# **Sheringham Shoal and Dudgeon Offshore Wind Farm Extension Projects**

Traffic and Transport Discussions with  
Norfolk County Council

Title:	
<b>Sheringham Shoal and Dudgeon Offshore Wind Farm Extension Projects Examination submission Traffic and Transport Discussions with NCC</b>	
PINS document no.:	
Document no.:	
Date:	Classification
<b>10.01.2023</b>	<b>Draft</b>
Prepared by:	
<b>Royal HaskoningDHV</b>	
Approved by:	Date:
<b>Sarah Chandler, Equinor</b>	<b>XX</b>

**Table 1-1 NCC Comments on SEP and DEP DCO documents and the Applicant's response**

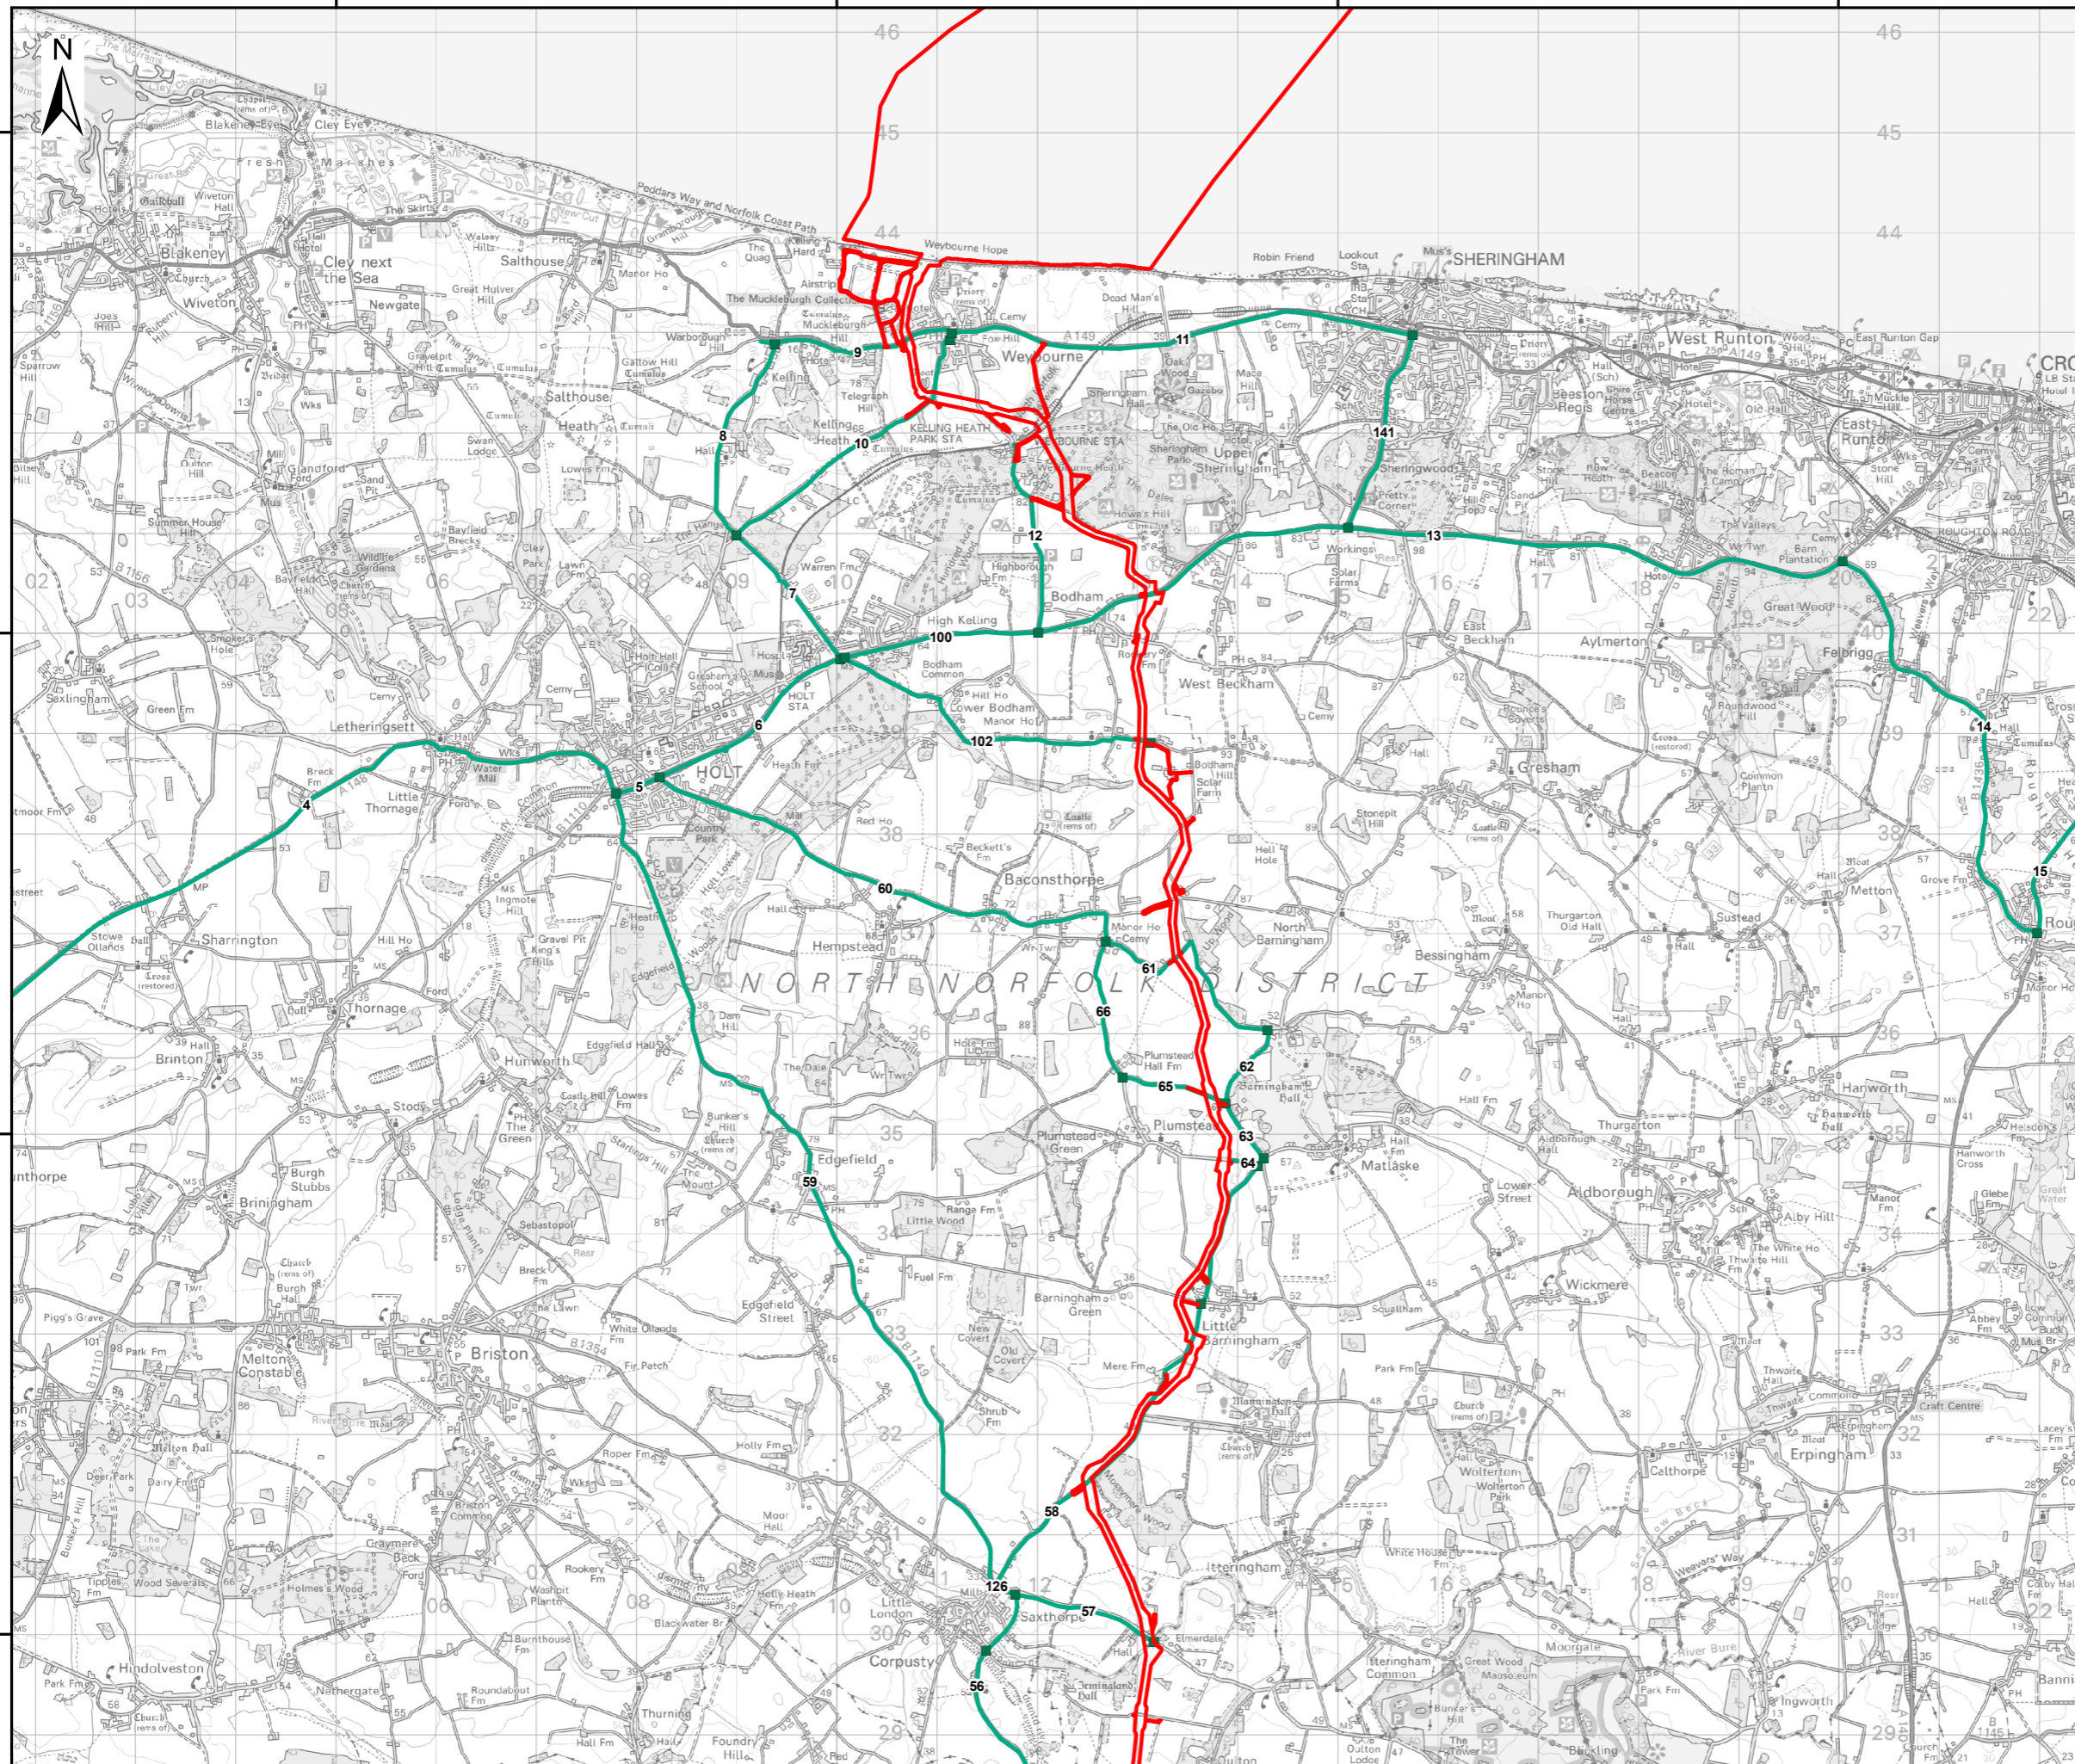
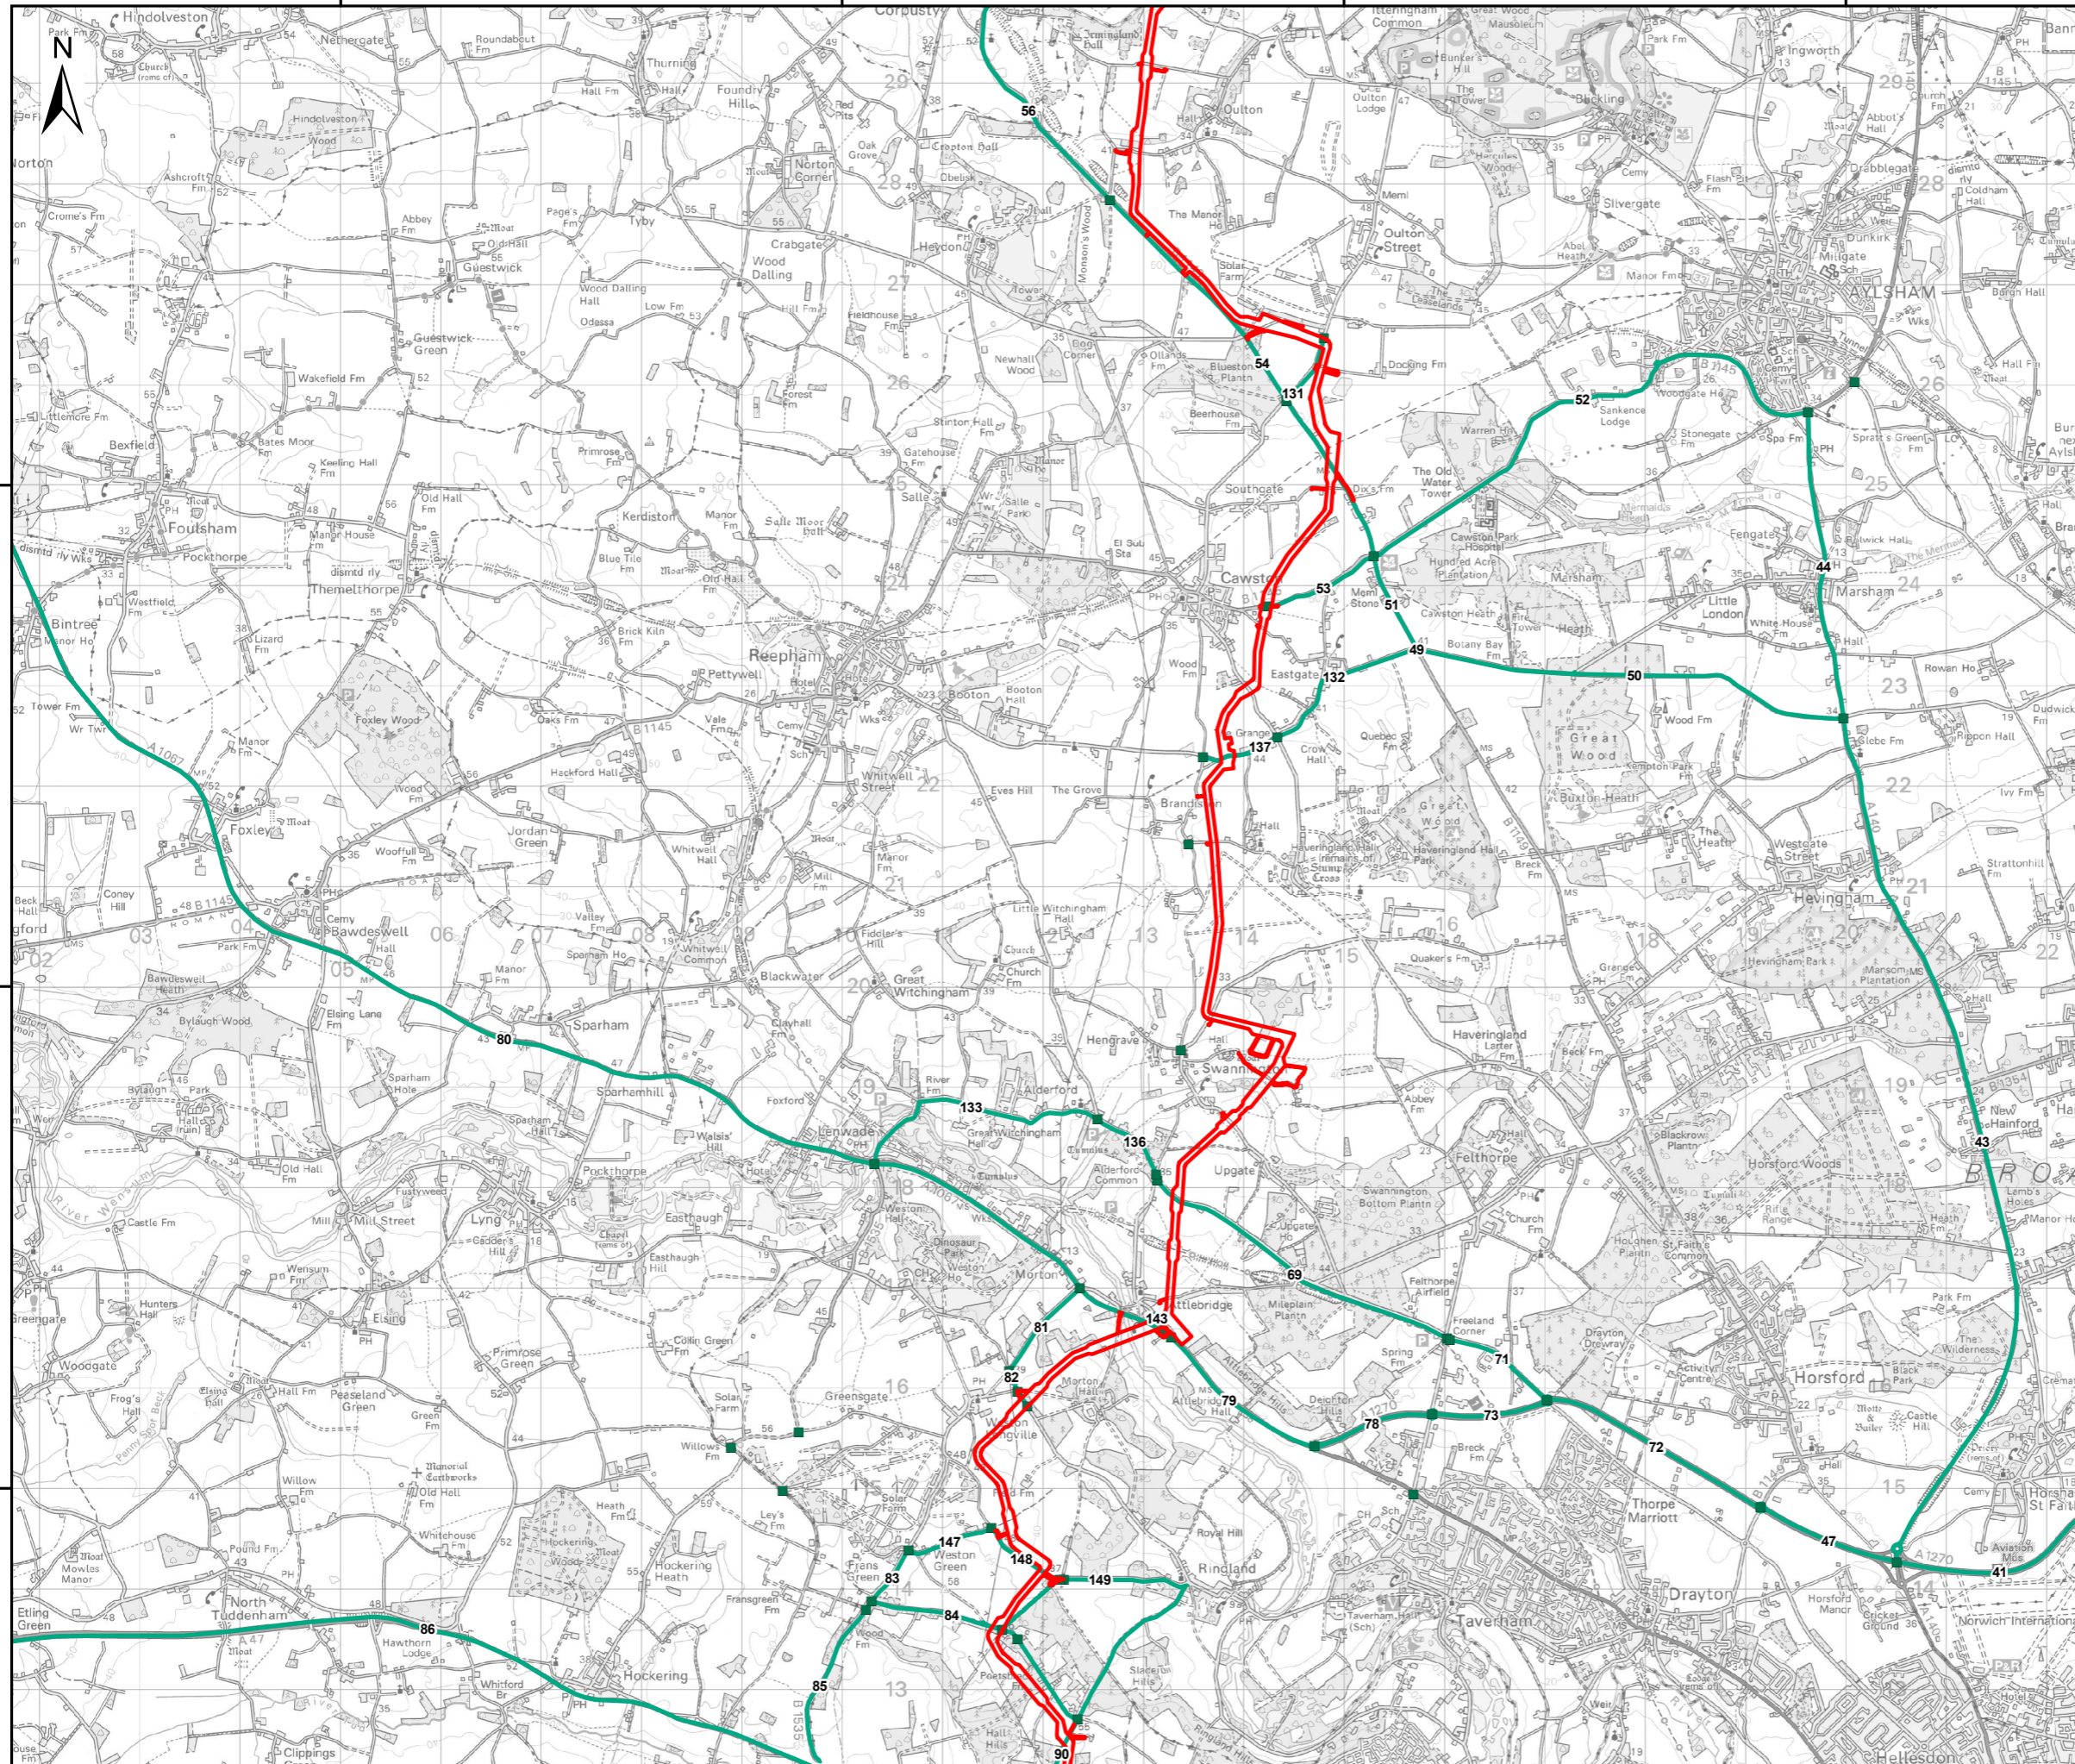
I.D.	NCC identified document, page, section number, etc.	NCC Comment	Applicant Response	Record of discussions with NCC
			<p>identified above. Section 2.3 of the OCTMP sets out how the routing of HGVs will be controlled.</p> <p>The Applicant however wishes to highlight an error with Figure 1 of the OCTMP [APP-301] which incorrectly shows HGVs being permitted through Weston Longville. The Applicant can confirm that this error will be corrected in a revision to the OCTMP and that no HGV traffic will be permitted to route via Weston Longville.</p>	
13	The [O]CTMP - para 32	Link 133 has a tight bend over a bridge and the crossroads/Link 150 are a nightmare in the peak times though not necessarily a reason to avoid. You need to demonstrate its suitability for use by HGV's	<p>Table 24-20 of Chapter 24 of the ES [APP-110] sets out SEP and DEP could result in a peak increase in all vehicles and HGV traffic via link 133 of 5% and 17% respectively.</p> <p>It can be identified from Table 24-48 of the Chapter 24 of the ES [APP-110] that due to the width of link 133, mitigation measures will be required to accommodate the forecast increase in HGV traffic.</p> <p>The measures outlined in Table 24-48 are captured within section 4.4 the OCTMP [APP-301] which is secured via Requirement 15 of the draft DCO [APP-024].</p> <p>Section 4.4 of the OCTMP outlines a range of measures, to manage the passage of SEP and/or DEP traffic along narrow roads, including:</p> <ul style="list-style-type: none"> <li>• Road/ junction widening;</li> <li>• Formalising existing informal passing places; or</li> <li>• Using mobile traffic management, such as: <ul style="list-style-type: none"> <li>• An escort vehicle to guide HGVs along roads and past oncoming traffic;</li> </ul> </li> </ul>	NCC confirmed that they are content with the clarification provided and that the measures outlined within the OCTMP to manage traffic movements are appropriate.
